Recommendation Report for Planning Permission for Works or Extension to a Dwelling

REF NO: **AW/335/14/HH**

LOCATION: 4 Tithe Barn Way
 Aldwick

PROPOSAL: Alterations, garage extension & new garden walls

Title
Block and Location Plans

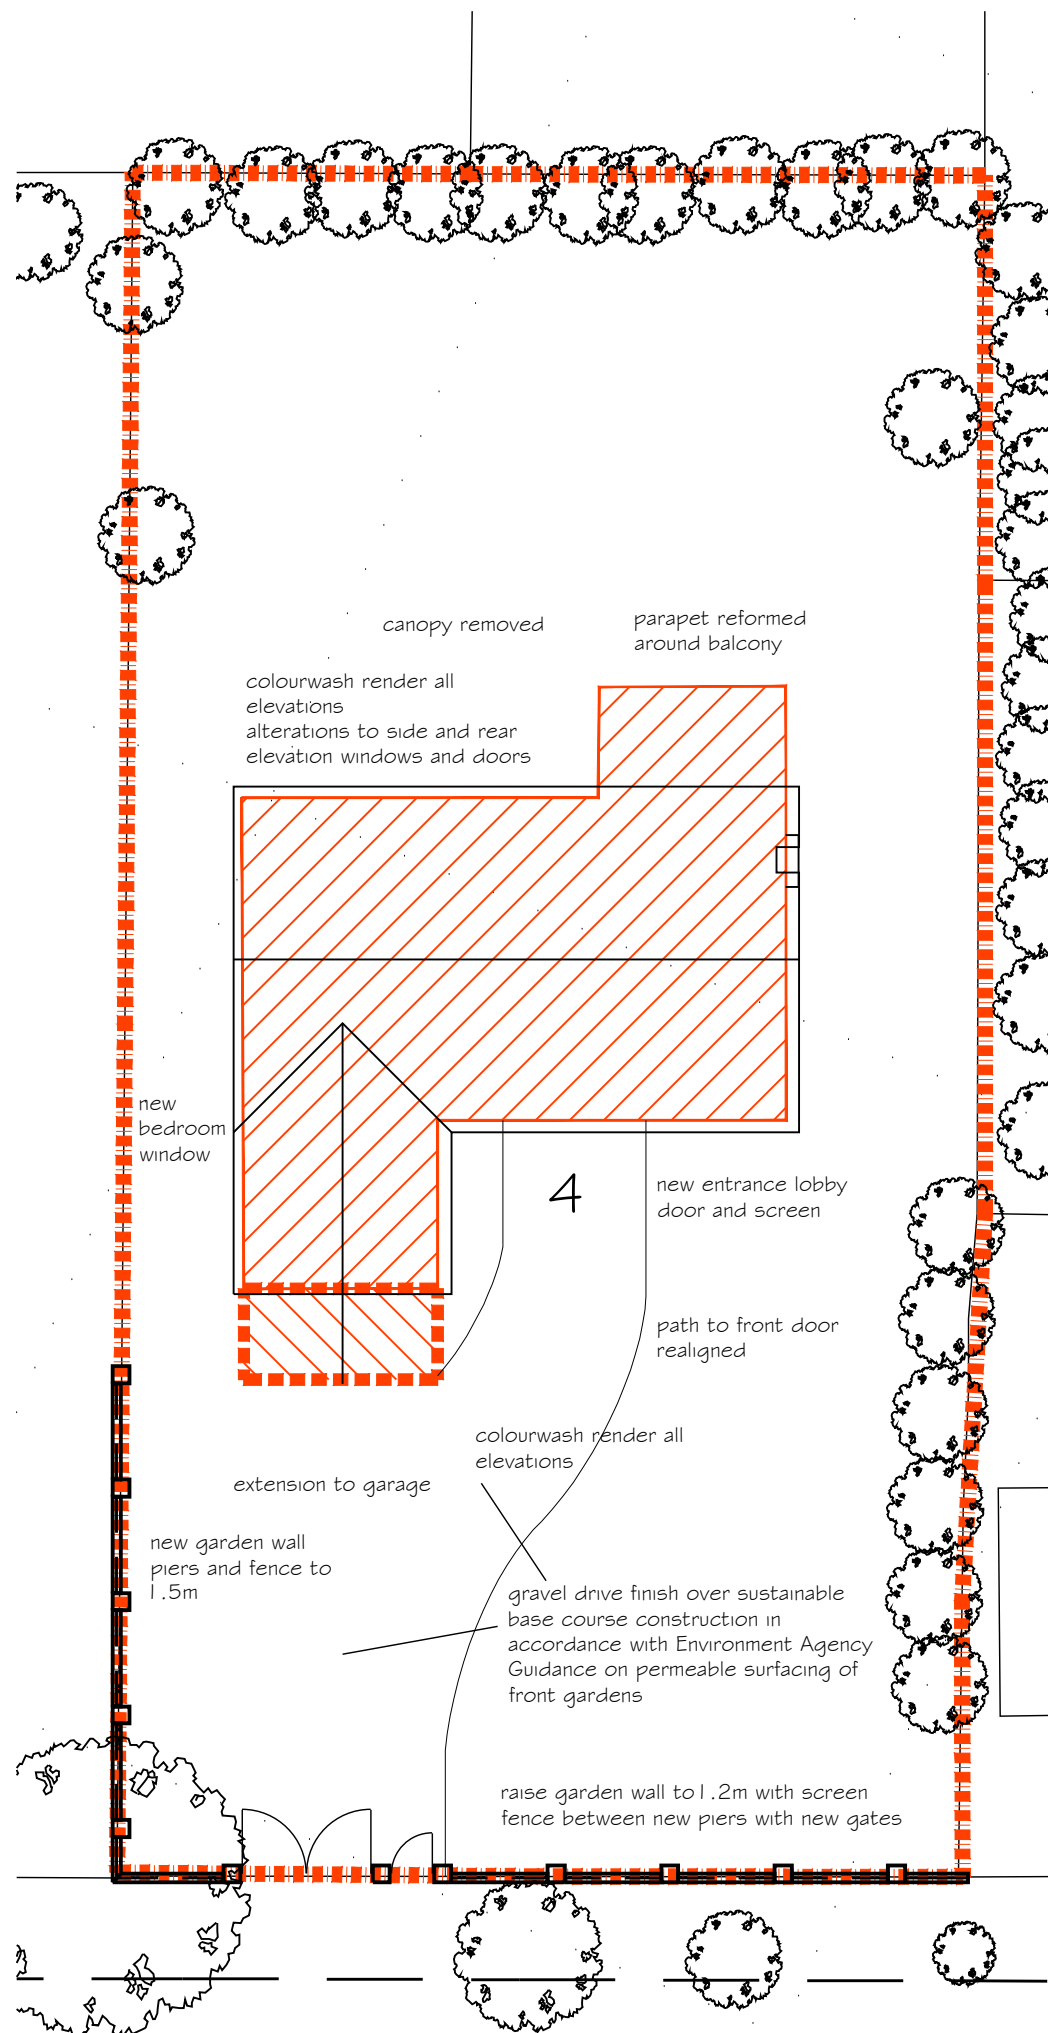
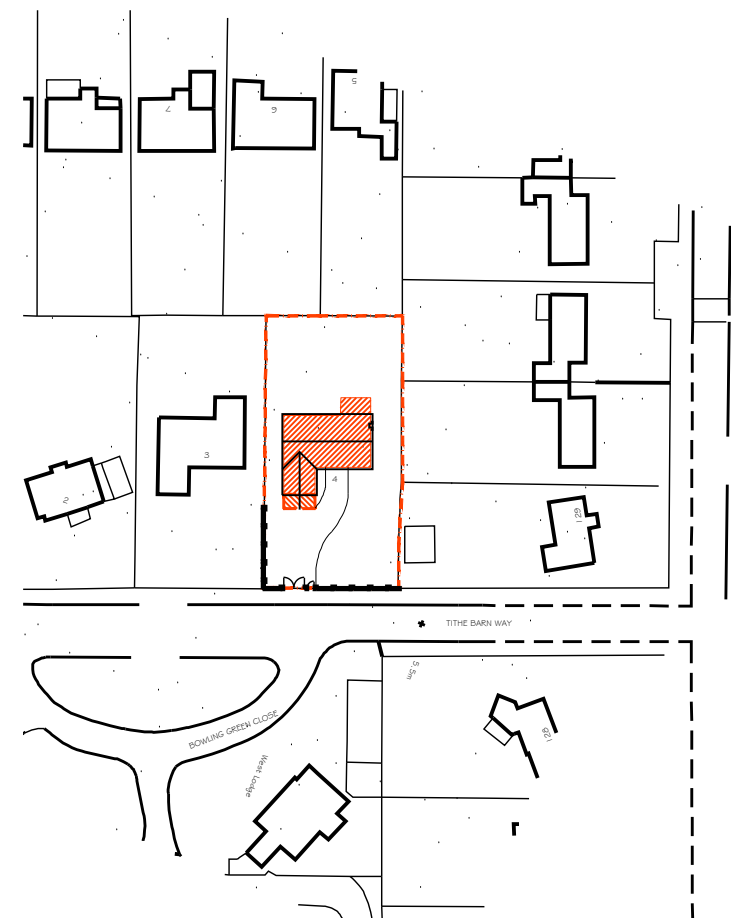
The proposed boundary treatment included in this application is not deemed to have an adverse impact upon the character of the conservation area. The proposal is for the erection of a 1.2 metres wall adjacent to the highway - under Schedule 2, Part 2, Class A of the Town and Country (General Permitted Development) Order 1995 (as amended) walls up to 1 metre in height can be erected without the need to obtain planning permission. Therefore, as the wall exceeds 1 metre in height the structure will require formal planning consent from the Council. It has been determined that the additional 0.2 metres is not unacceptable in terms of its impact upon the character of the area. The application also includes the erection of 1.5 metre high fencing on the side boundaries of the property, these works would benefit from permitted development rights under Schedule 2, Part 2, Class A, which allows for the erection of walls and means of enclosure up to 2 metres in height. Whilst,

It has also been considered that the wall will be located within close proximity of two trees the subject of Tree Preservation Orders (TPO) and as such these works would need to be conditioned to ensure that the works and development of the site is carried out in accordance with the limitations of BS 5837 (2012).

The proposed works to the existing dwelling are considered to have an acceptable impact upon the appearance of the conservation area. However, concerns have been raised by the Council's Conservation Officer in relation to the proposed wall adjacent to the highway. The existing 0.4 metre high wall adjacent to the highway continues along the frontage of 3 Tithe Barn Way and has a limited impact upon the appearance of the street scene and conservation area. Whilst, the proposed wall will be higher than the existing boundary treatment it is considered that it will not have an unacceptable adverse impact upon the appearance of the conservation area. It should be noted that 128 and 129 which are located at the northern end of Tithe Barn Way have side boundaries which run adjacent to the highway with boundary treatments of 1.8 metres in height.

Most notable is the brick built and cream painted wall located some 5 metres to the north of the application site. Therefore, the proposed wall has been deemed to have an acceptable impact upon the character of the conservation area.

- 6 The development of the boundary wall/fence, shall not be commenced until a report in accordance with BS 5837 (2012) has been submitted and approved by the Local Planning Authority to ensure protection of the Root Protection Area (RPA) of the two pine trees forward of the primary elevation. Fencing shall also be deployed in accordance with BS5837 (2012) and Section 9, around each tree to the RPA as calculated in accordance with Table 2 of BS5837 (2012). Within the areas so fenced off the existing ground must not be cultivated, nor must it be lowered or raised or added to by the importation and spreading of top soil unless agreed by the Local Planning authority. There must be no materials, temporary buildings, plant machinery or surplus soil placed or stored thereon.

Title
Ground Floor
Plans as Proposed

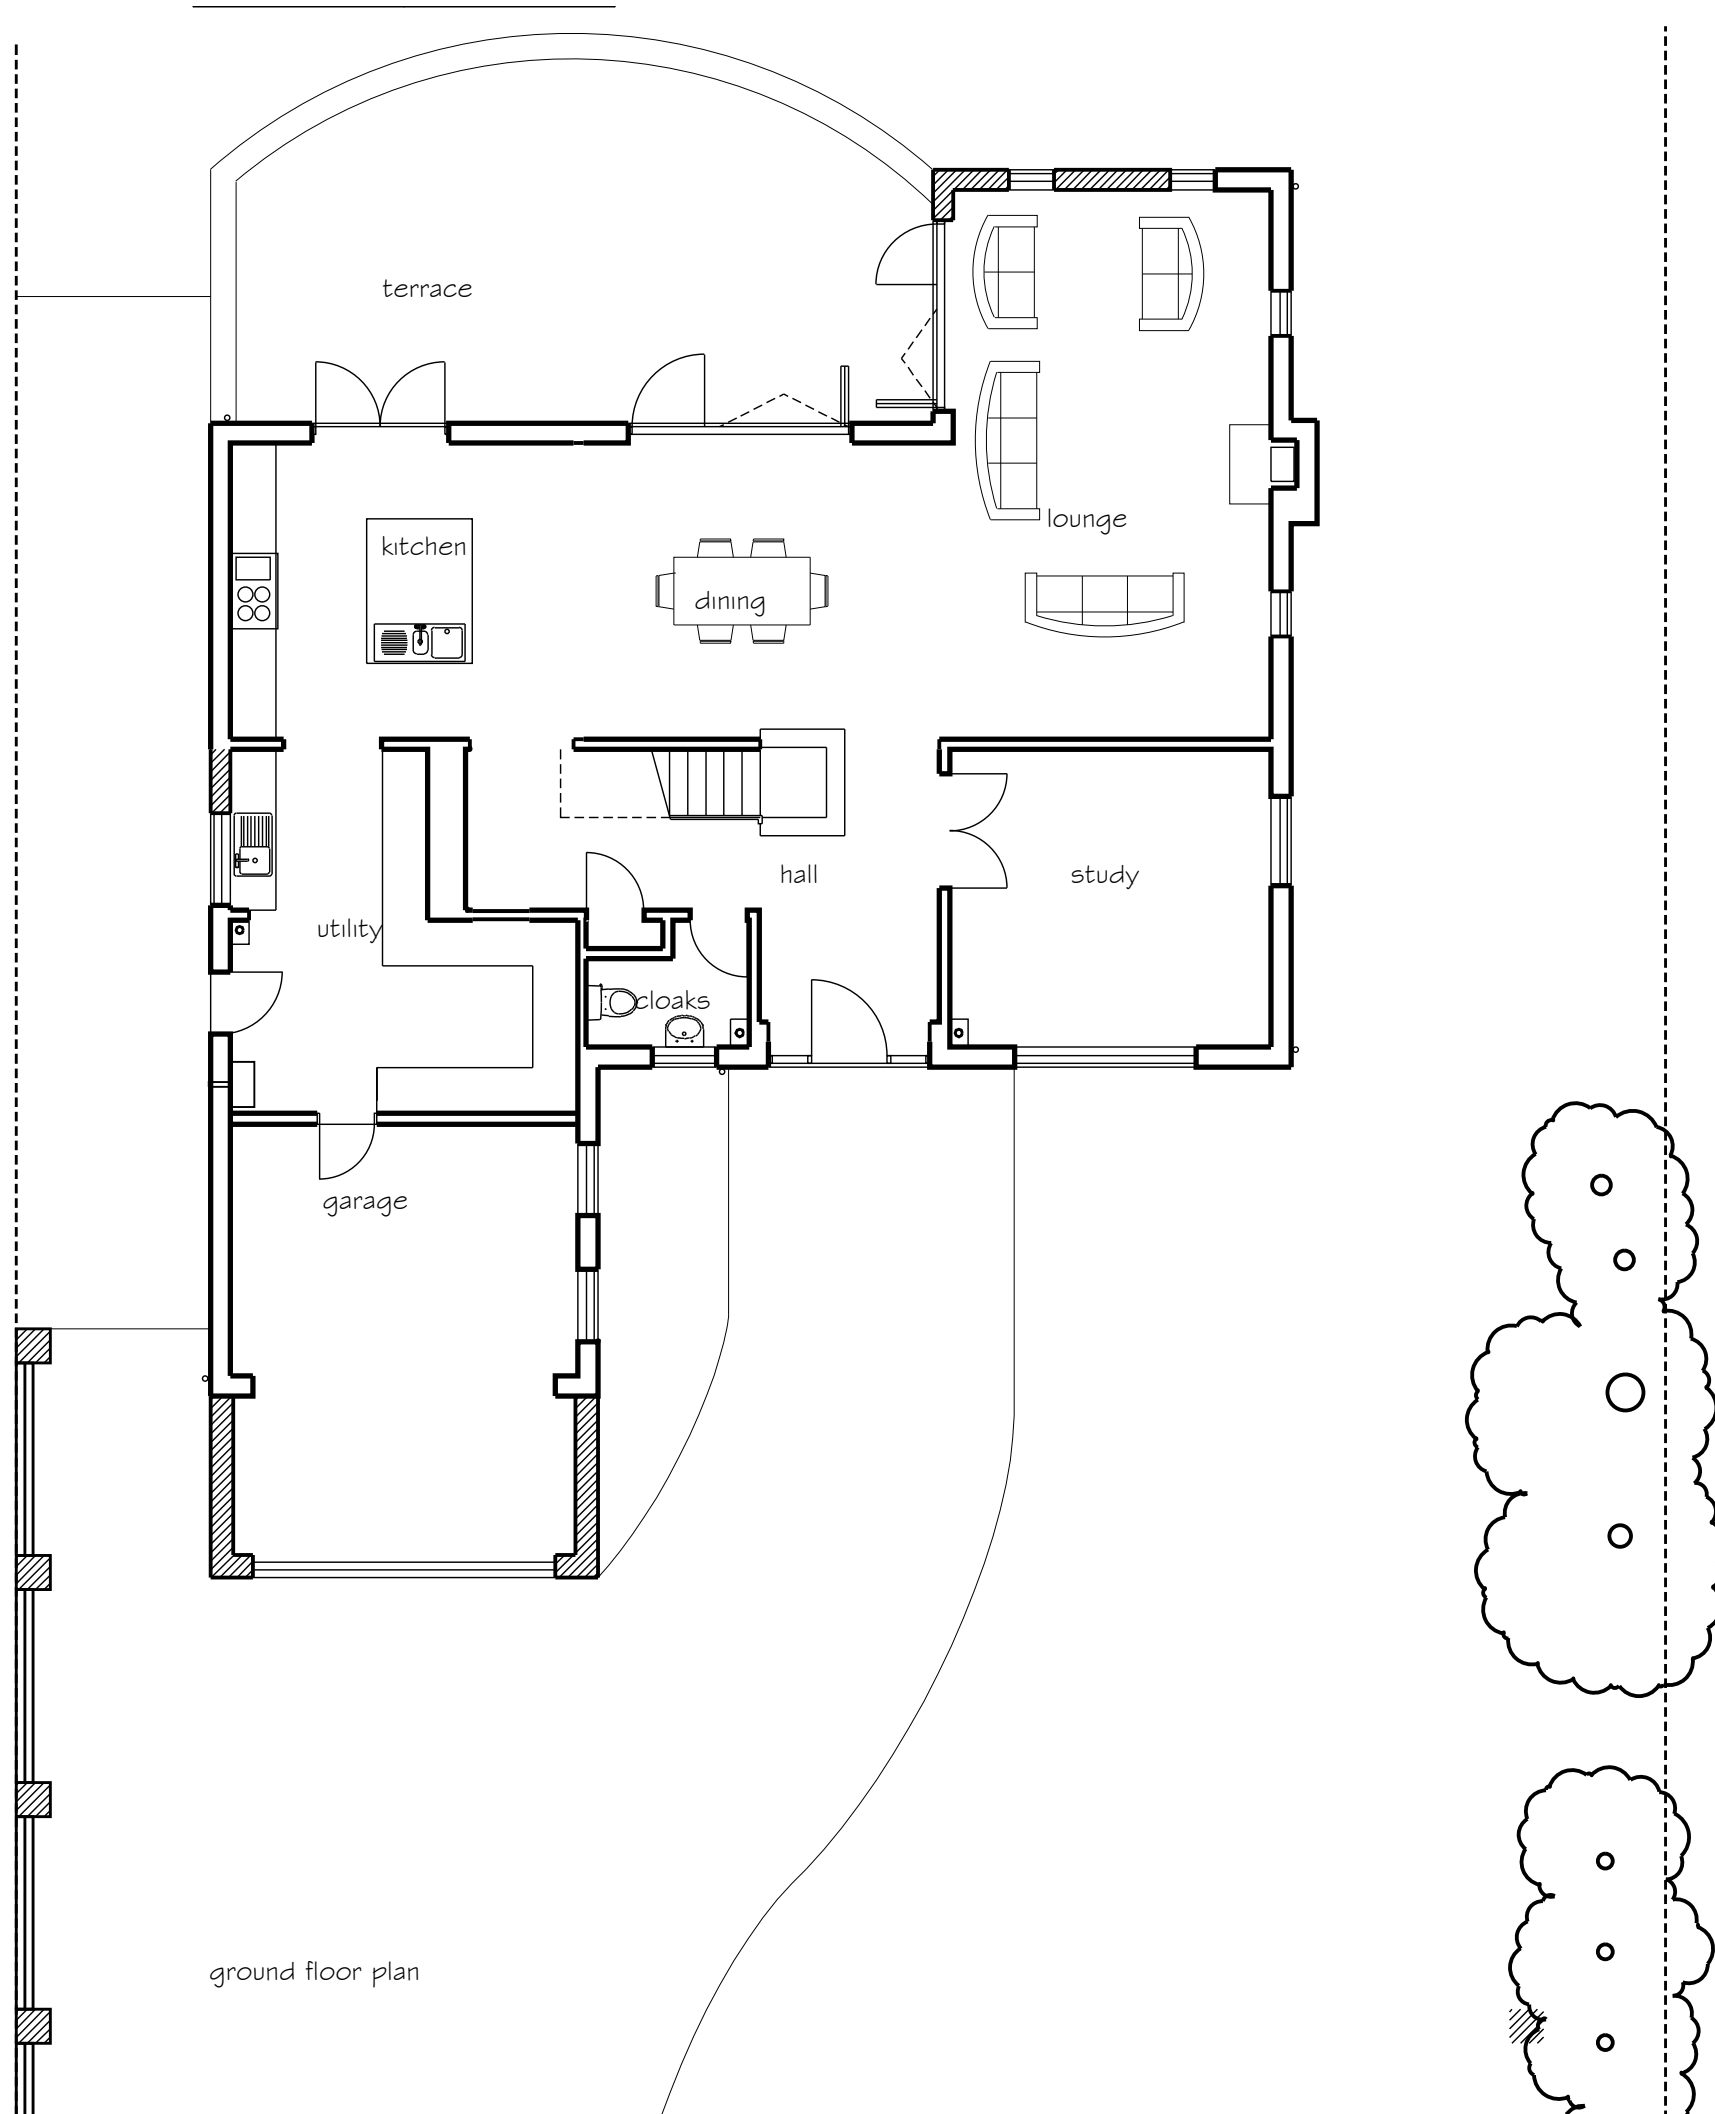
The proposed front extension will project 2.4 metres further forward from the existing primary elevation. The proposed extension will be well integrated with the existing property with the ridge line matching that of the existing dwelling and the use of matching materials. The extension will be set back from the highway by approximately 13 metres and as such the proposal will not have no adverse impact upon the appearance of the street scene.

- 5 The materials and finishes of the external roof of the extension hereby permitted shall match in colour and texture those of the existing building.

Title
West and North
Elevations as Proposed

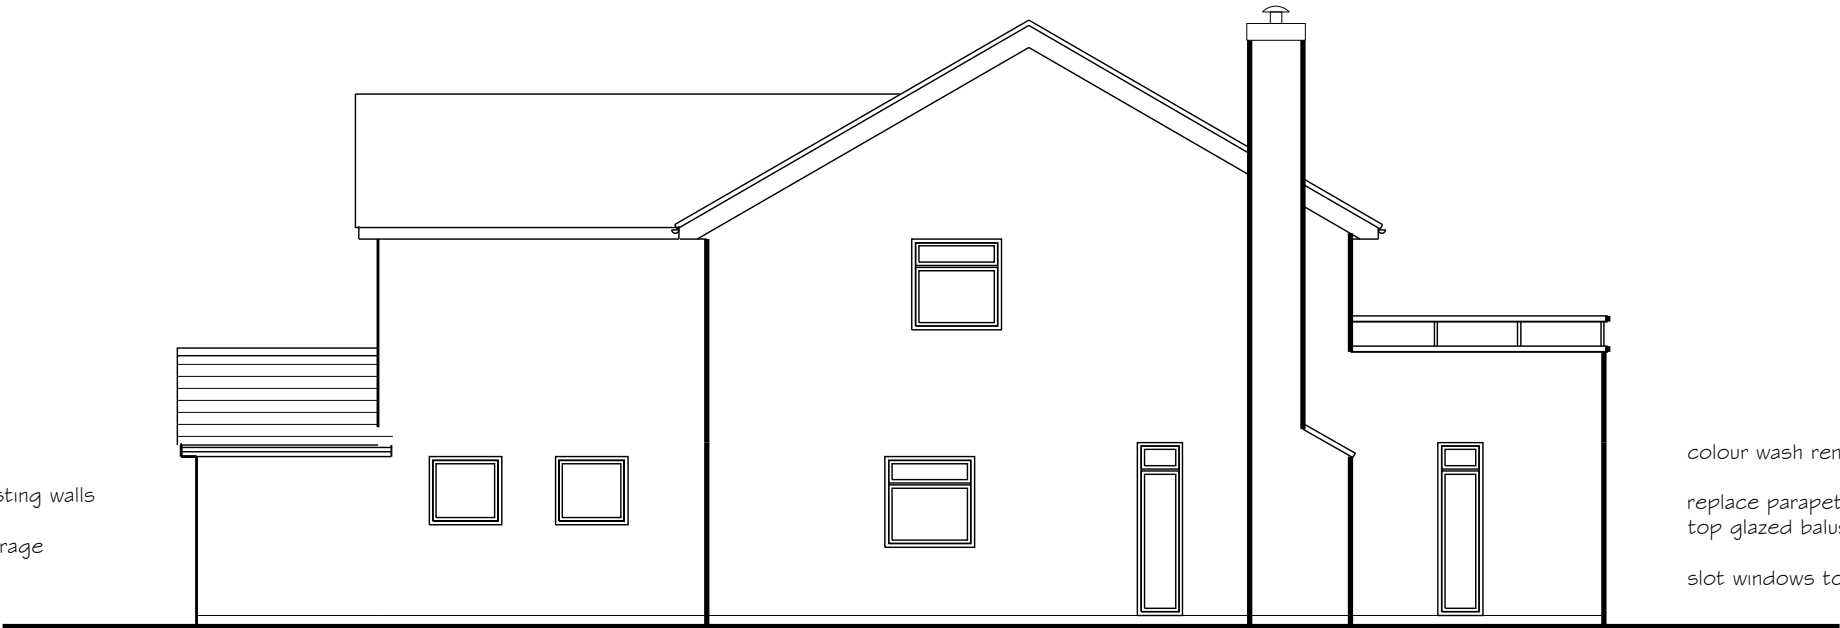
The proposed alterations to the balcony have also been considered. However, given that the balcony is an existing feature upon the dwelling it has not been deemed to give rise to any additional overlooking of neighbour properties.
